## **DEPARTMENT OF PUBLIC WORKS**

### **MEMORANDUM**

TO: All Staff  
FROM: Public Works Planning Review Team  
DATE: June 4, 2020  
SUBJECT: Mayr CB-20-00005  
Tax Parcels: 951338 and 951339

Below please find an updated unified siteplan. Legend: roads/driveway marked in black, D – drainfield, H – House, S – sportscourt, P – power boxes, W – water access points.

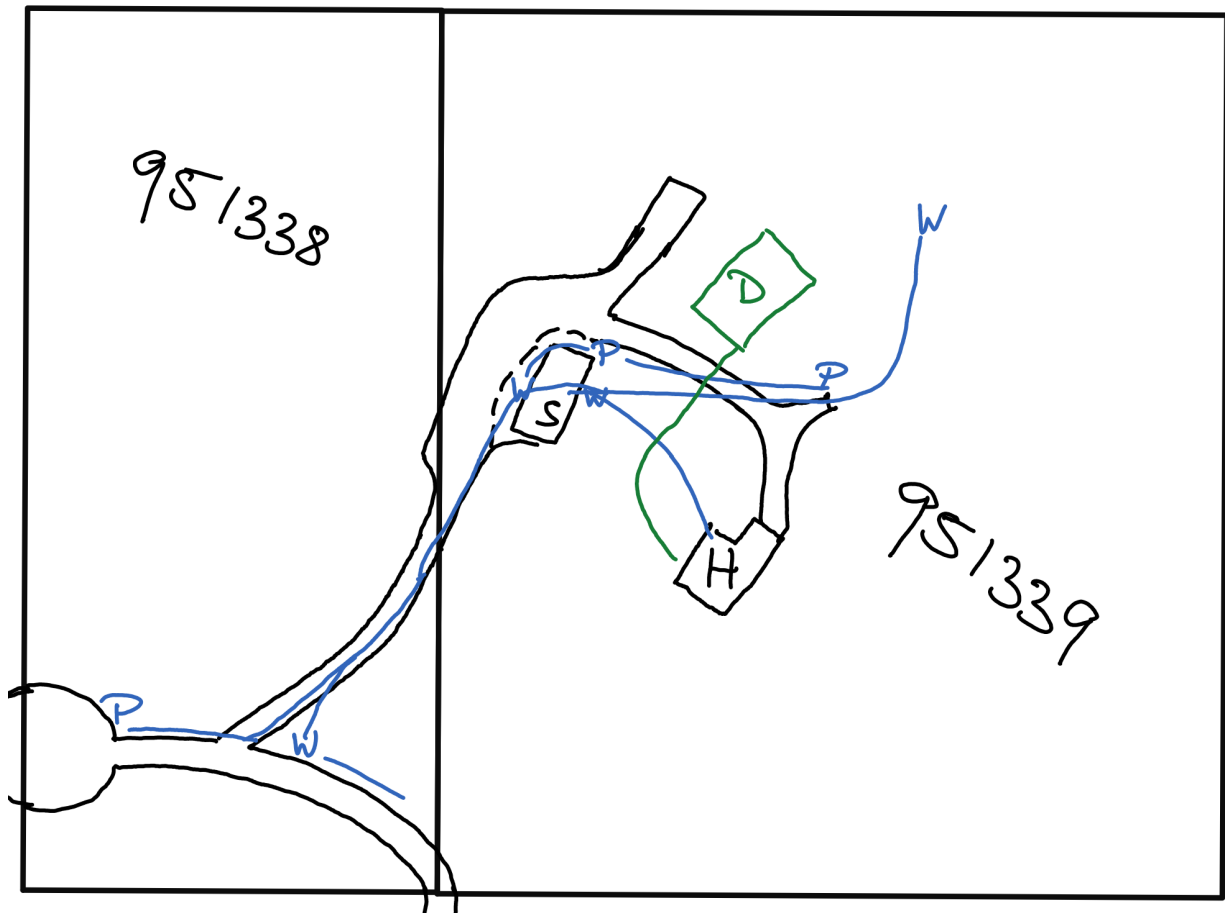
- a) An approved access permit shall be required from the Kittitas County Department of Public Works prior to creating any new driveway, access or performing any work within the county road right of way.
- b) The parcel combination will use the existing access.
- c) Any further subdivision or lots to be served by proposed access may result in further access requirements. See Kittitas County Road Standards.
